TARRAWONGA LIFE OF MINE MODIFICATION – RESPONSE TO DPIE-WATER RECOMMENDATIONS

Please find enclosed a response to the recommendations received from the Department of Planning, Industry & Environment – Water and Natural Resources Access Regulator in relation to the Tarrawonga Coal Mine Life of Mine Modification 7 (refer Table 1).

Table 1 – Response to Response to Supplementary DPIE-Water Recommendation

Figure 2 Current Groundwater Monitoring Locations

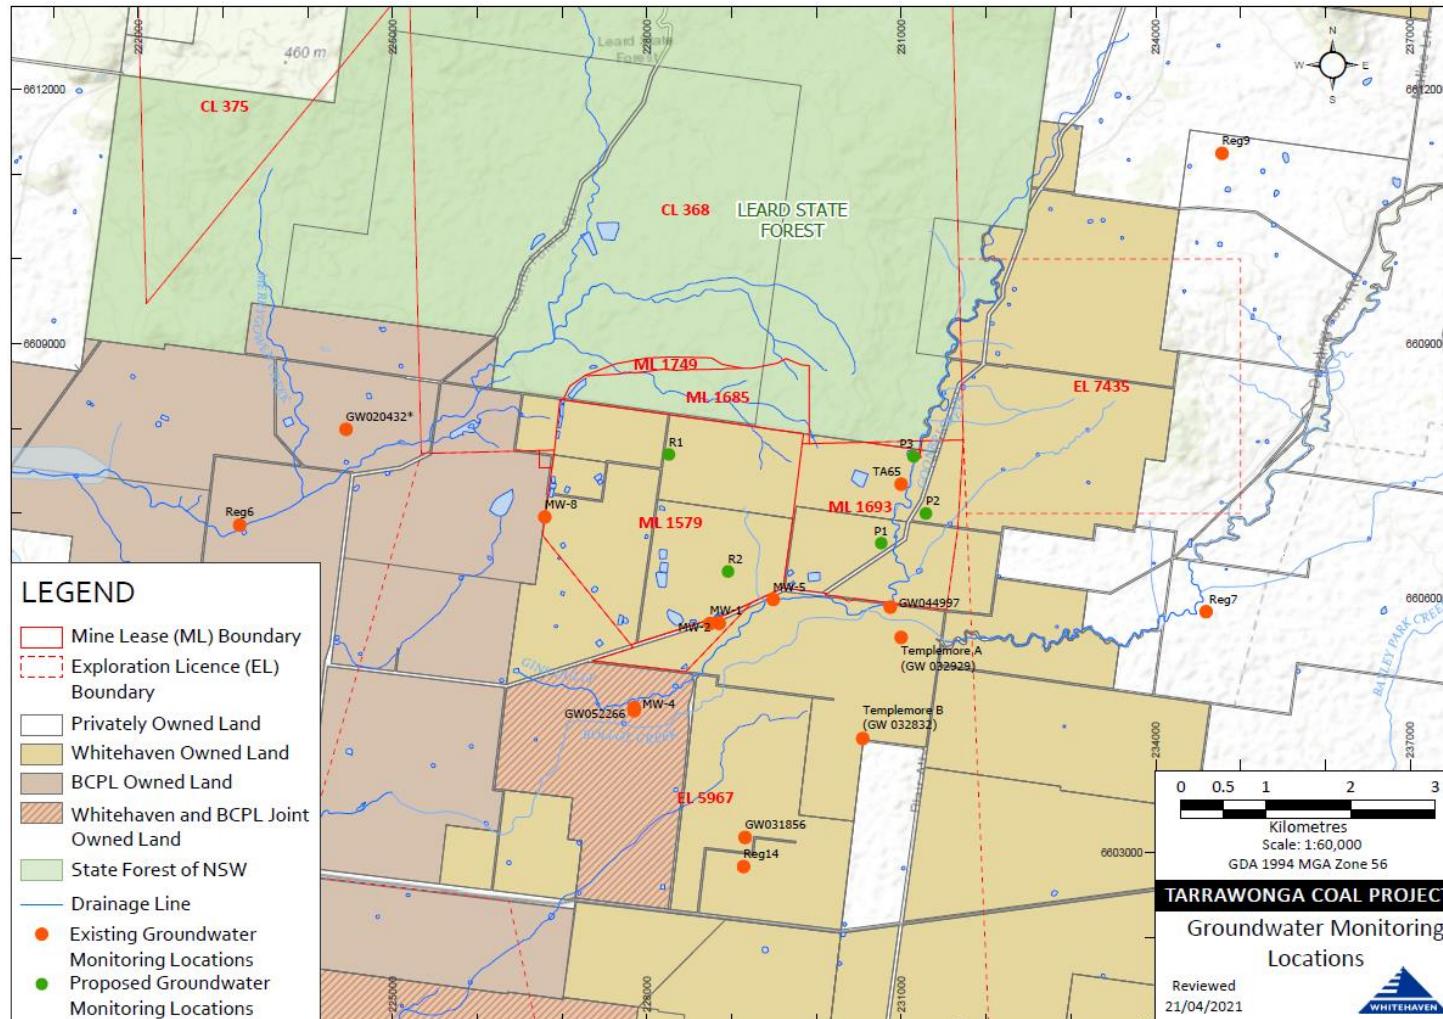
Recommendation	TCPL Response
Post-approval Recommendation <i>Update the Water Management Plan in consultation with DPIE - Water. The update should include:</i> <i>Additional groundwater monitoring and reporting. There is need for several clustered alluvial sites east of the pit and west of Goonbri Creek to be installed promptly.</i> <i>A plan for the revision of the groundwater model</i> <i>Addressing the commitment that has been made to ensure the new site access road and intersection would be designed to meet the requirements of the Upper Namoi Valley Floodplain Management Plan. An application for a flood work approval will not be required where it is approved under the Water Management Plan.</i>	In the Tarrawonga Modification 7 Groundwater Assessment, HydroSimulations (2019) recommends five monitoring locations be added to the existing groundwater monitoring program currently implemented at the Tarrawonga Coal Mine. Three of five additional monitoring sites recommended by HydroSimulations (2019) would observe the status and any potential groundwater impacts to the alluvium as mining progresses to the east. This includes two bores that would be located between the Open Cut and Goonbri Creek and a further bore east of Goonbri Creek. Revision and validation of the groundwater model is required under PA 11_0047 Schedule 3, Condition 39(iii), as described in the response above. TCPL will liaise with Department of Planning, Industry and Environment – Water Division with regards to the incorporation of the new site access road in the Water Management Plan.
